From: Nicola Swann
Sent: 17 November 2021 11:43
To: Planning.Responses <Planning.Responses@arun.gov.uk>
Subject: Pagham responses

Pagham Parish Council considered the following applications at a meeting of its Planning Committee Advisory Group held on 16th November 2021. In accordance with a scheme of delegation dated 4th May 2021, it makes the following comments:

P/147/21/RES – Land adjacent to Sefter School House Sefter Road Bognor Regis PO21 3EE. Approval of reserved matters following P/116/19/OUT for 4 No semi detached 3 bed and 2No detached 4-bed dwellings with associated access, parking & gardens (resubmission following P/111/21/RES).

Project
Land adjacent to Seftor School House
Seftor Road
Bignor Regis
PO21 3EE
Drawing Title
Plots 2 and 3
Floor Plans and Section

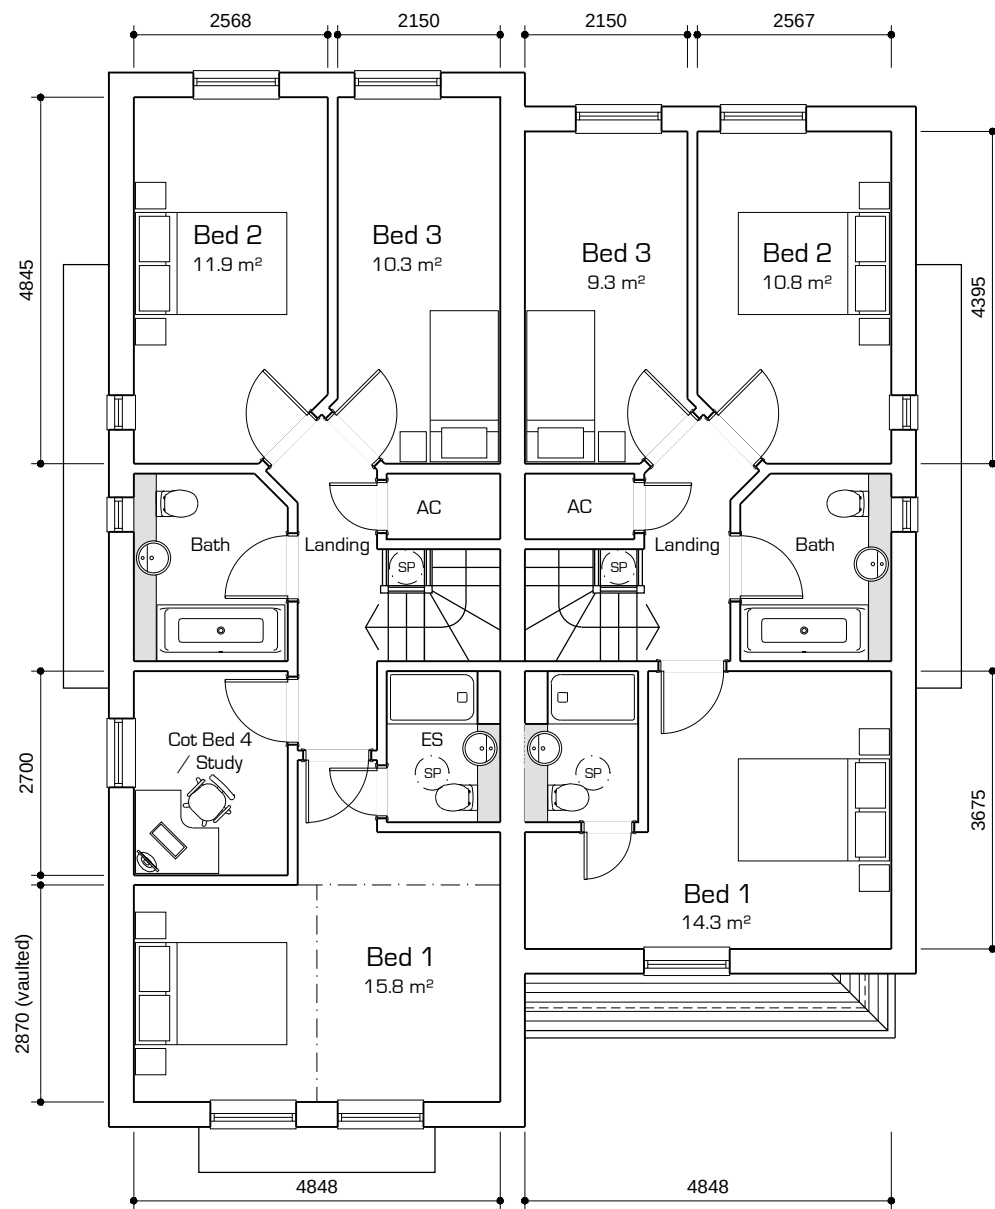
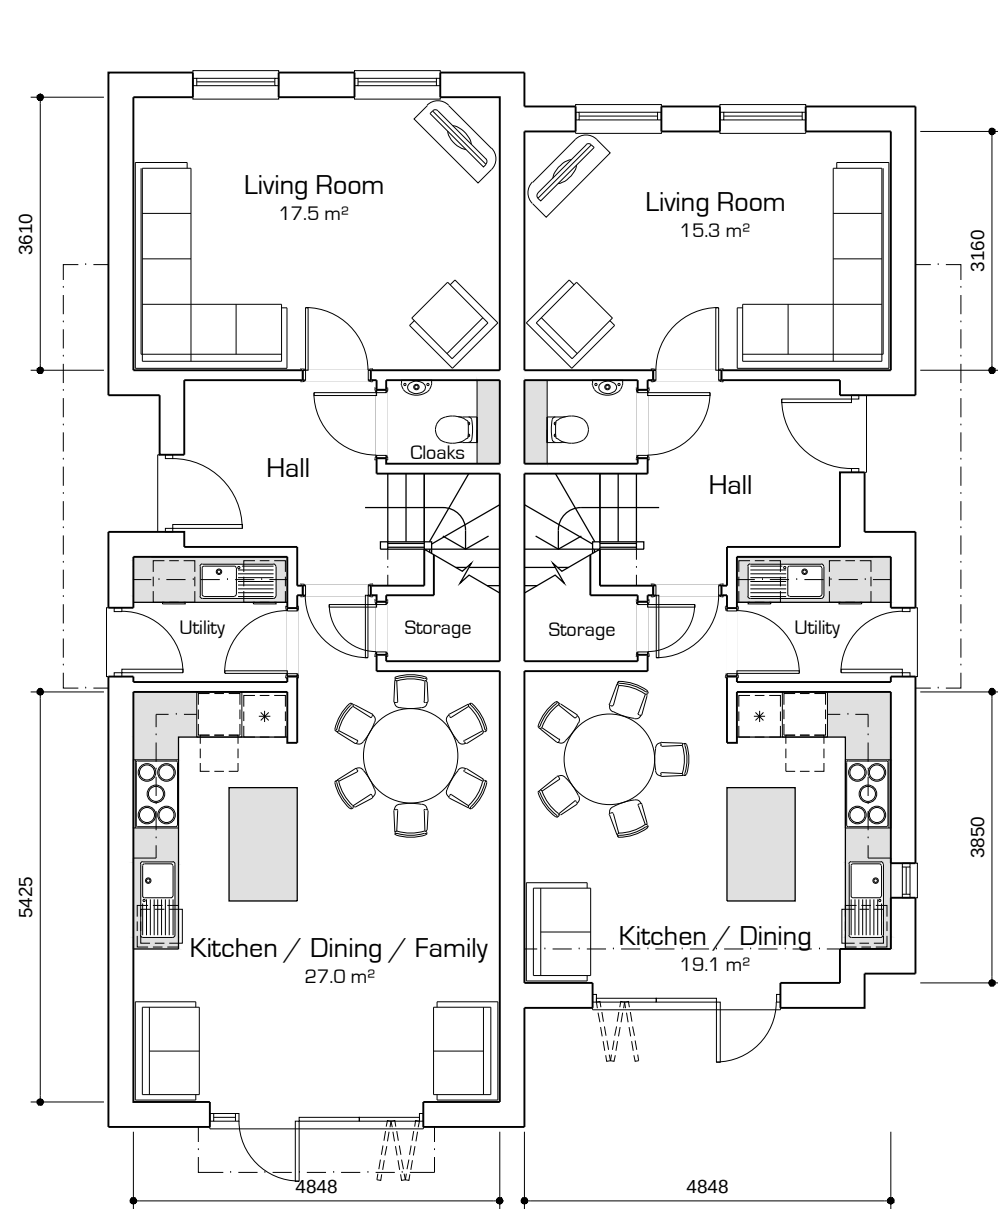
- Plots 1 & 2 have very limited outdoor space
- There is limited communal open space provided. The area at the front of the estate, which would inevitably attract children as a play space, is too near the access to Sefter Road.
